NATIONAL GRID (YORKSHIRE GREEN ENERGY ENABLEMENT PROJECT)
 ILLUSTRATIVE PLAN: SP005 ACCESS DURING CONSTRUCTION PHASE - OVERTON
 REGULATION 5(2)(o)
 SHEET 1 OF 1

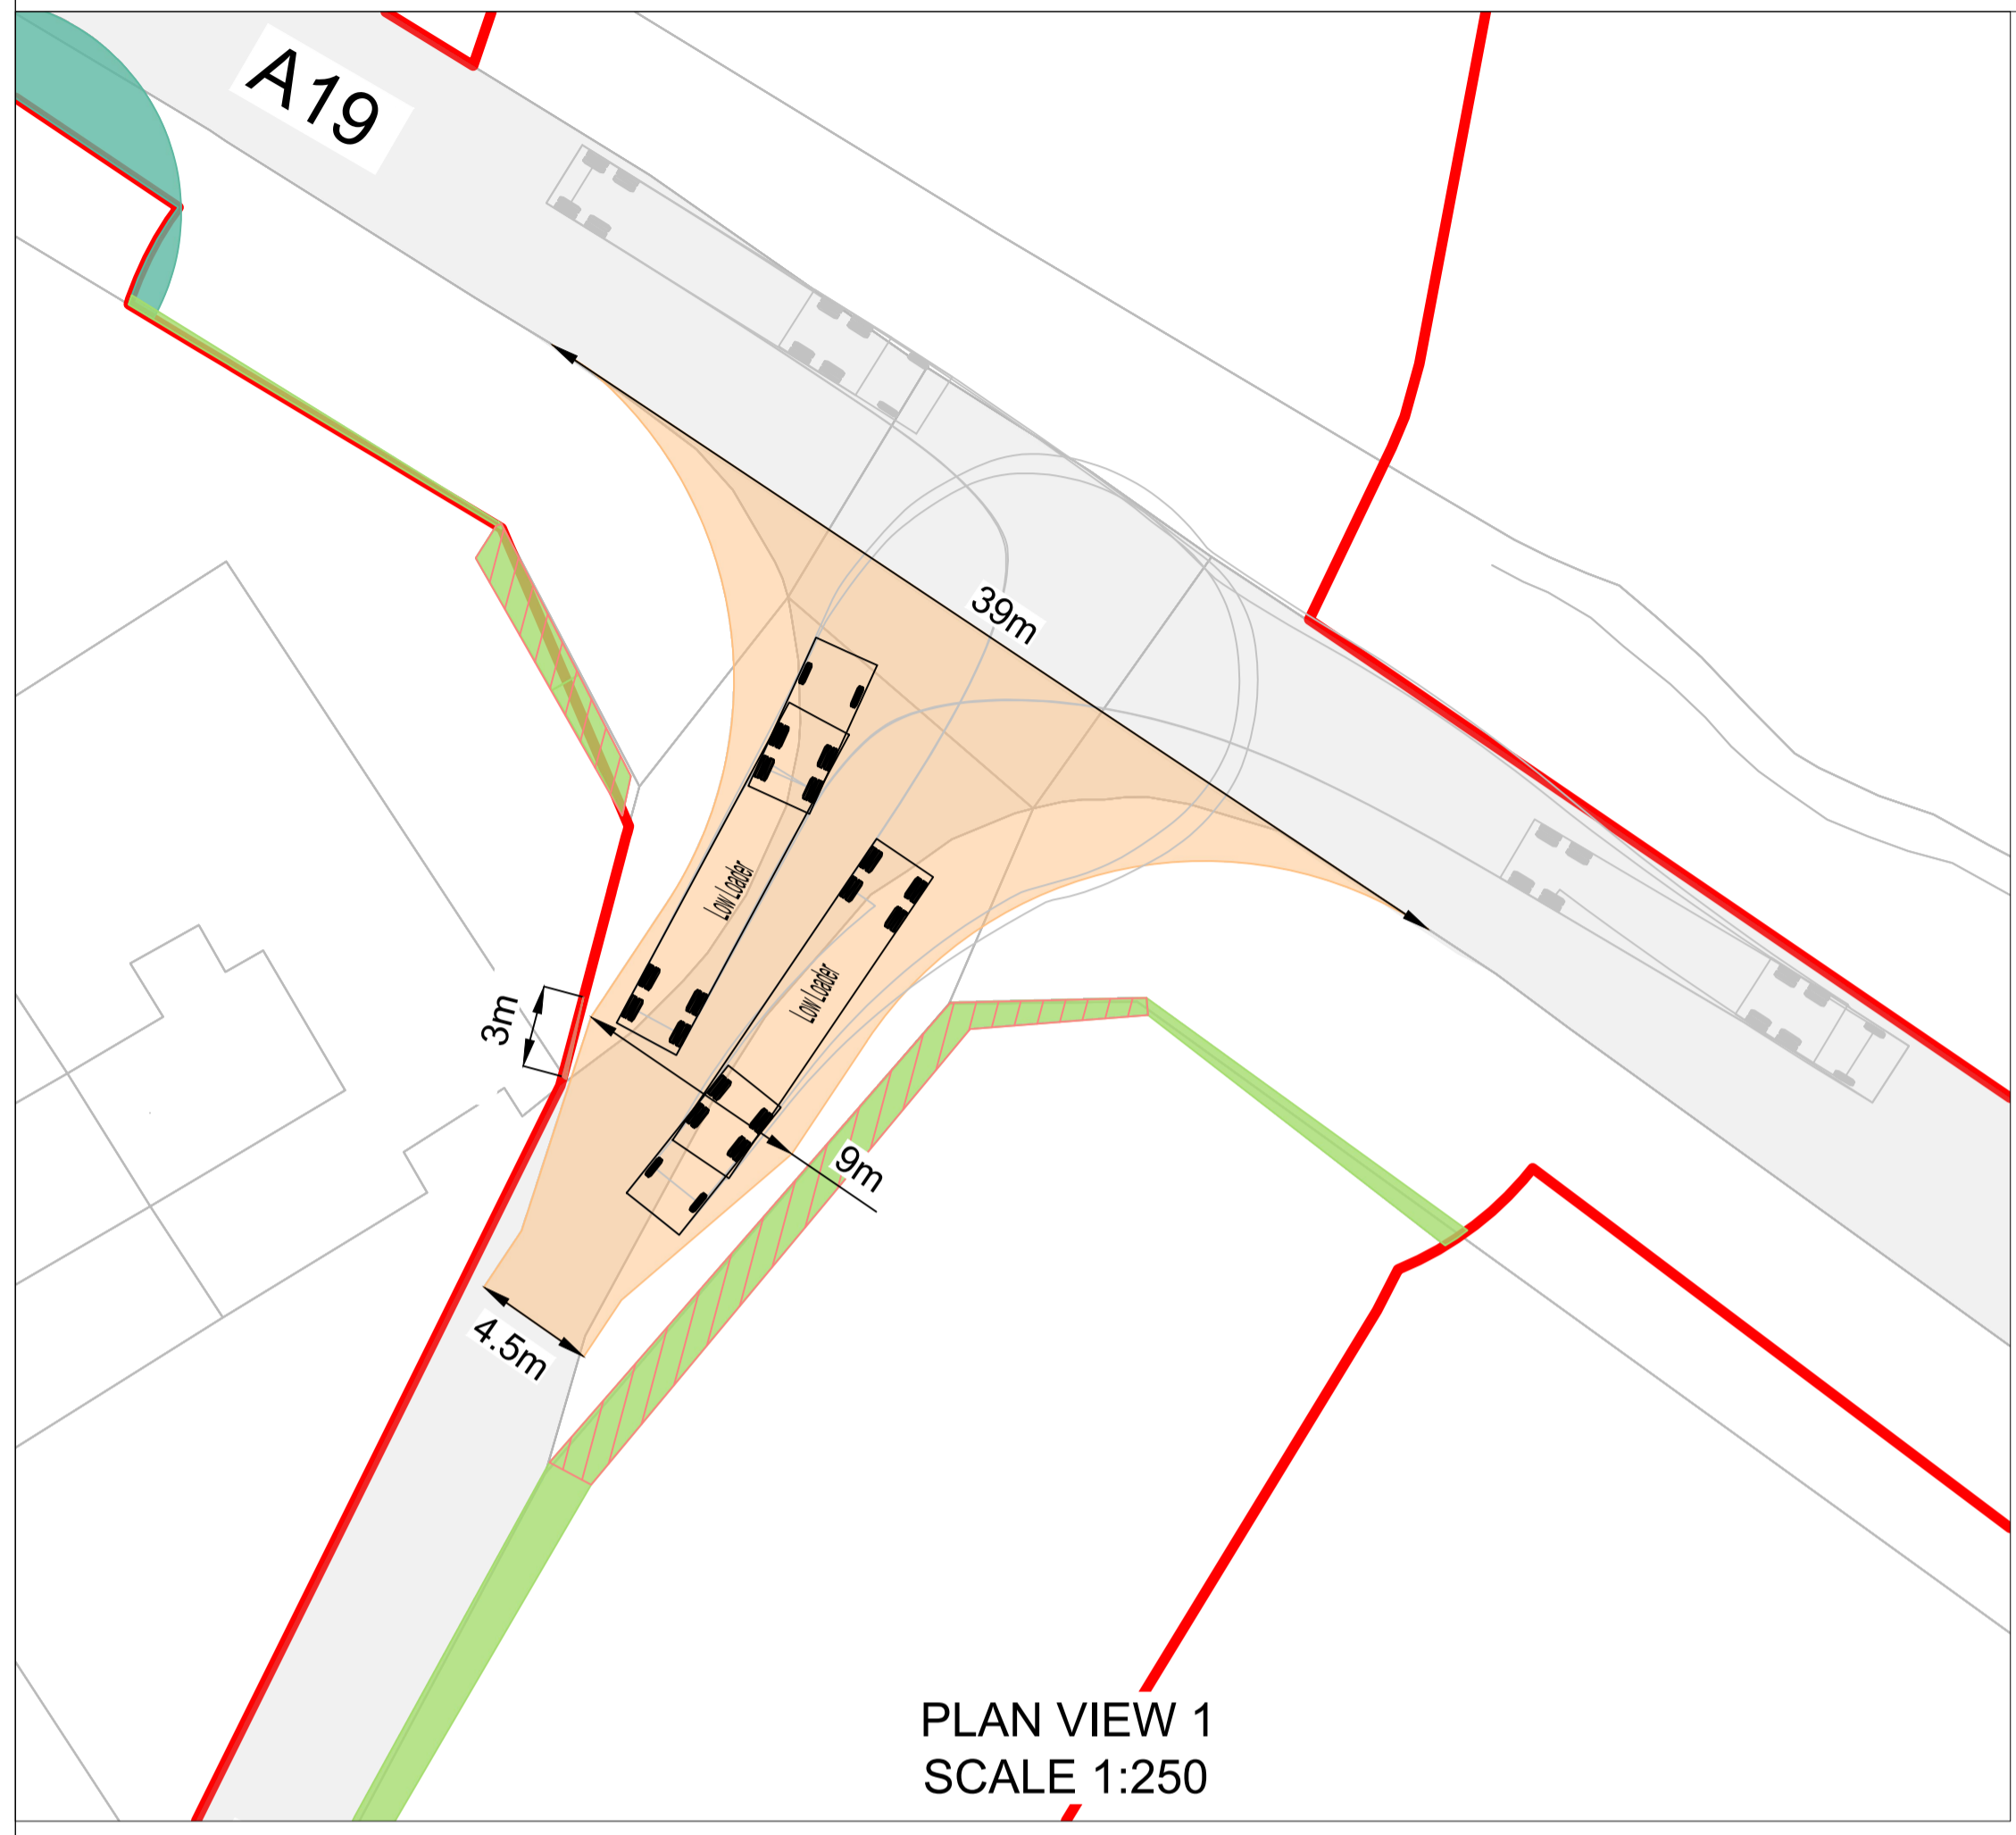
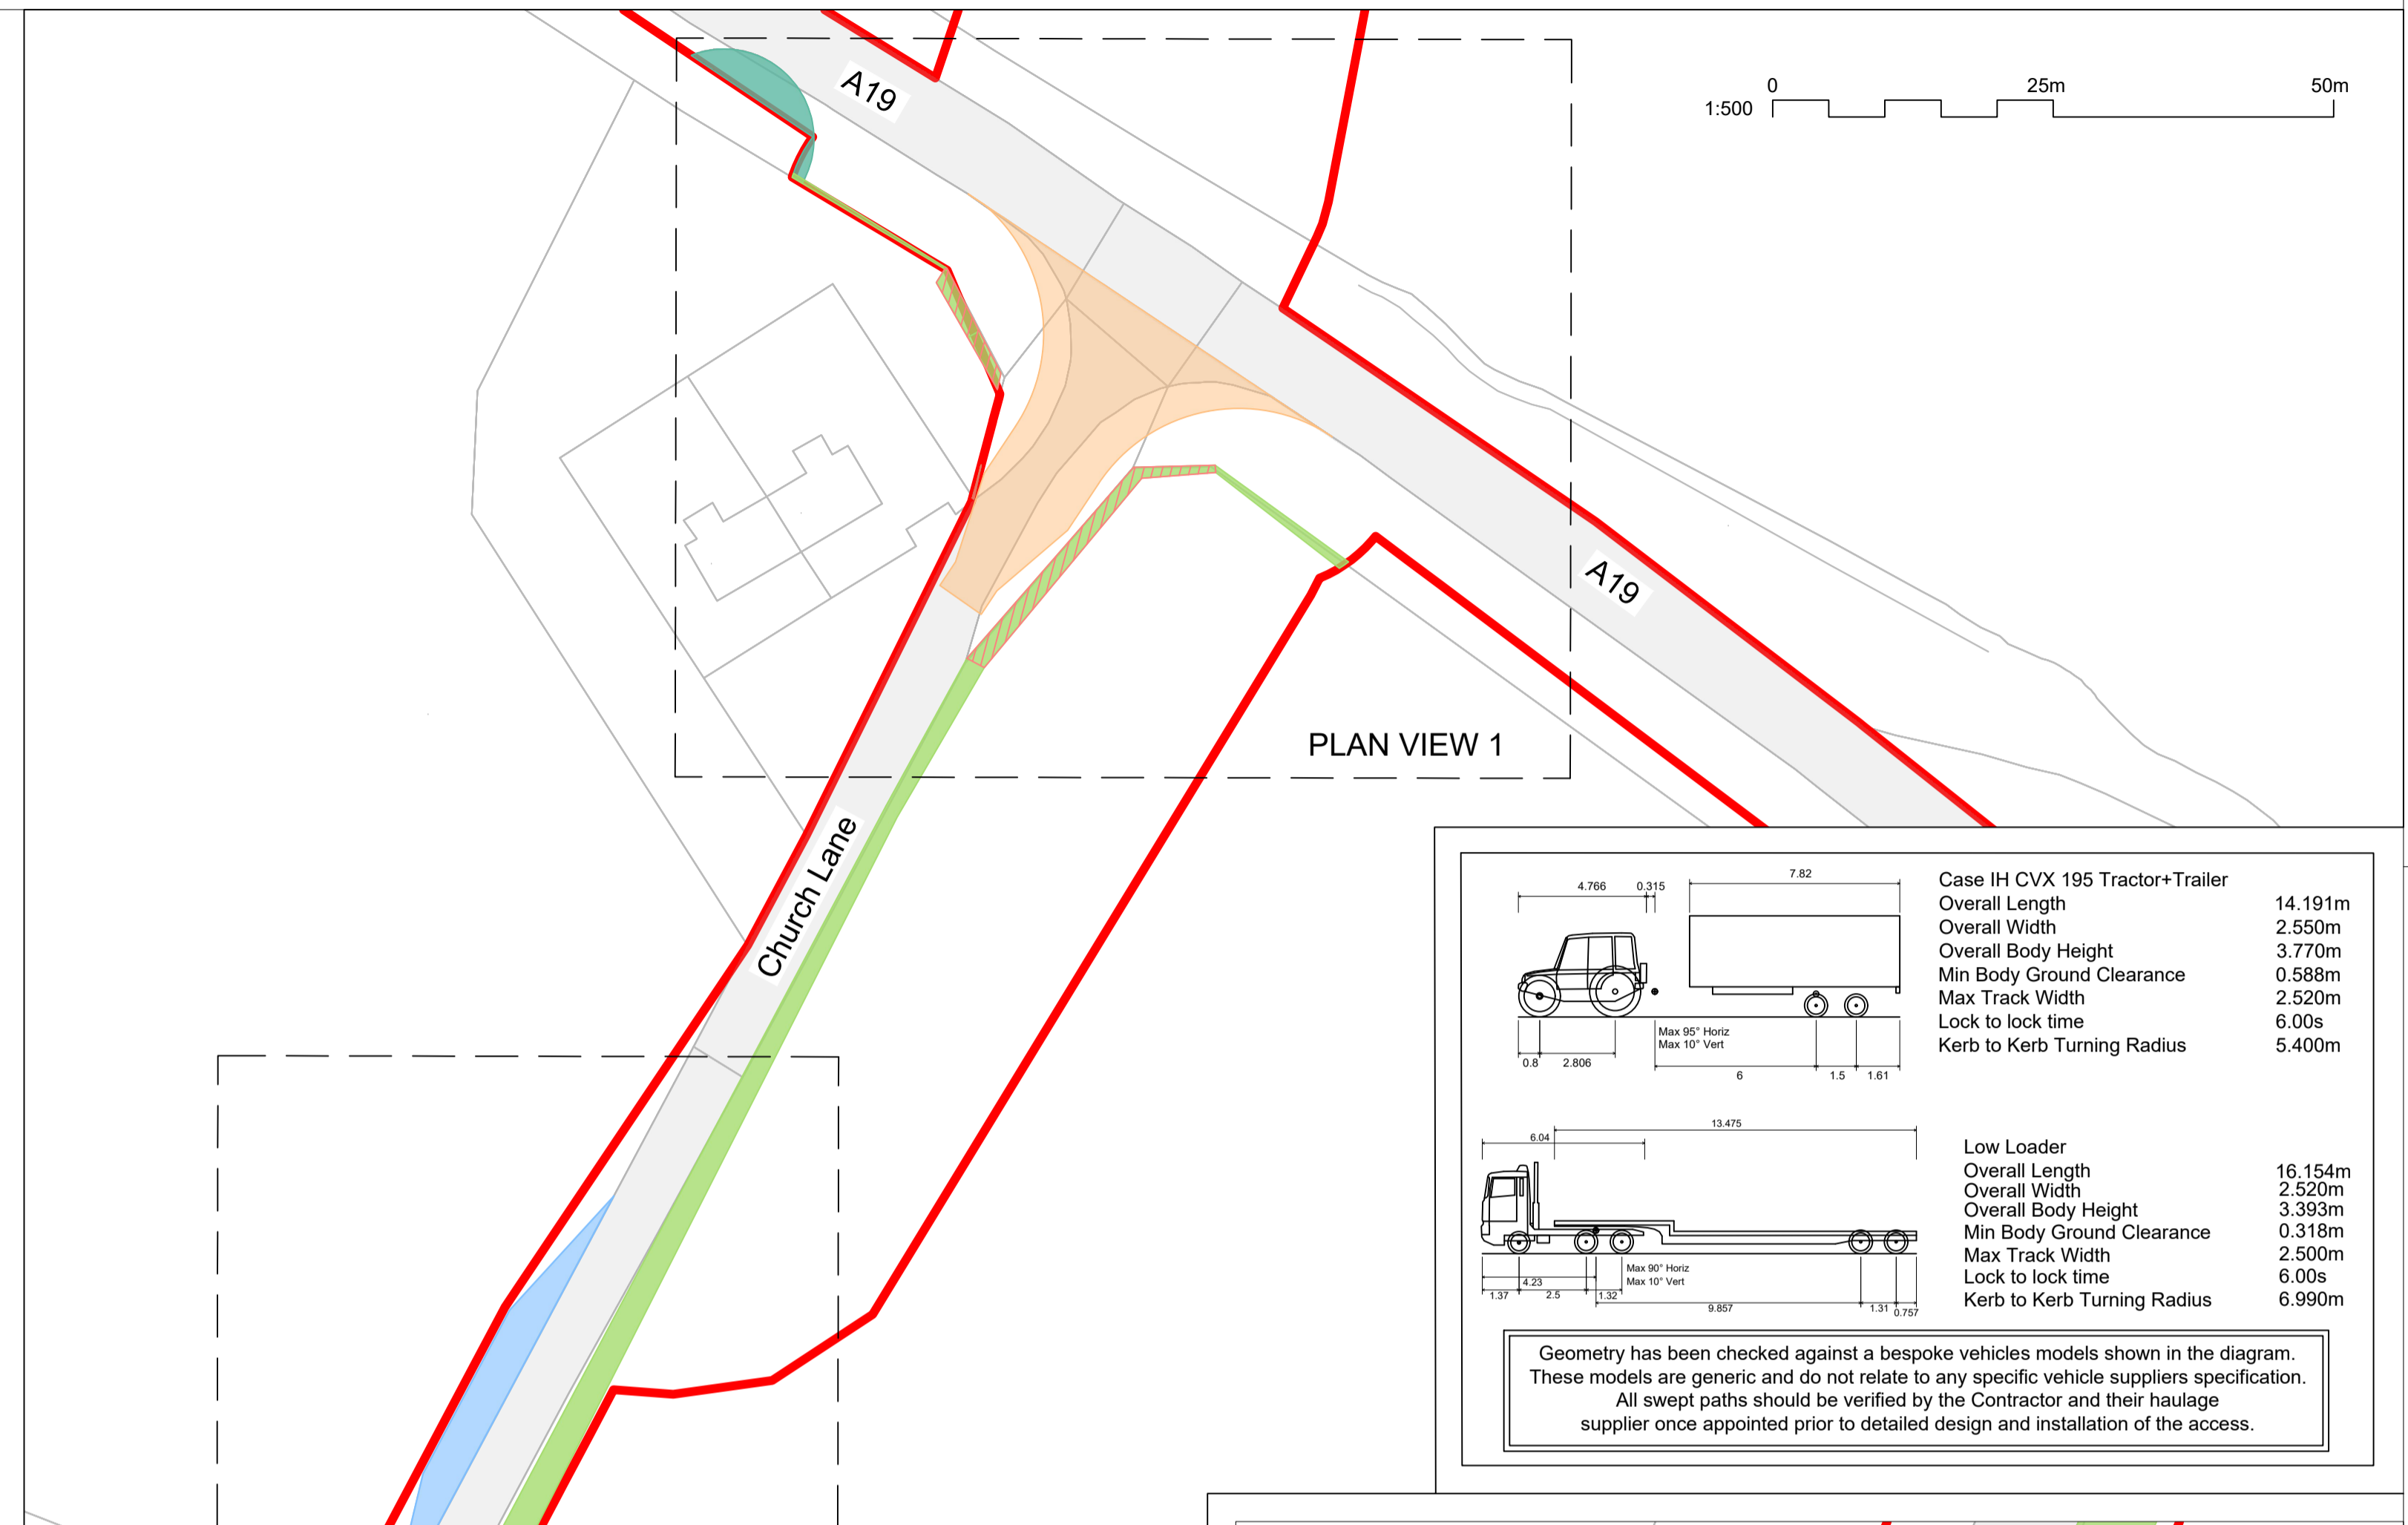
1.3.2	<p>Illustrative Plan: SP005 Access During Construction Phase [REP4-026], Appendix D a) Is this the level of detail that you would find useful post consent as part of the THPS? b) If not, what else would be of use?</p>	<p>a) Yes, in the main, subject to the inclusion of the items shown in b) b) The proposed materials to be used/ thicknesses etc shown on the plans and any new drainage/ existing drainage</p>
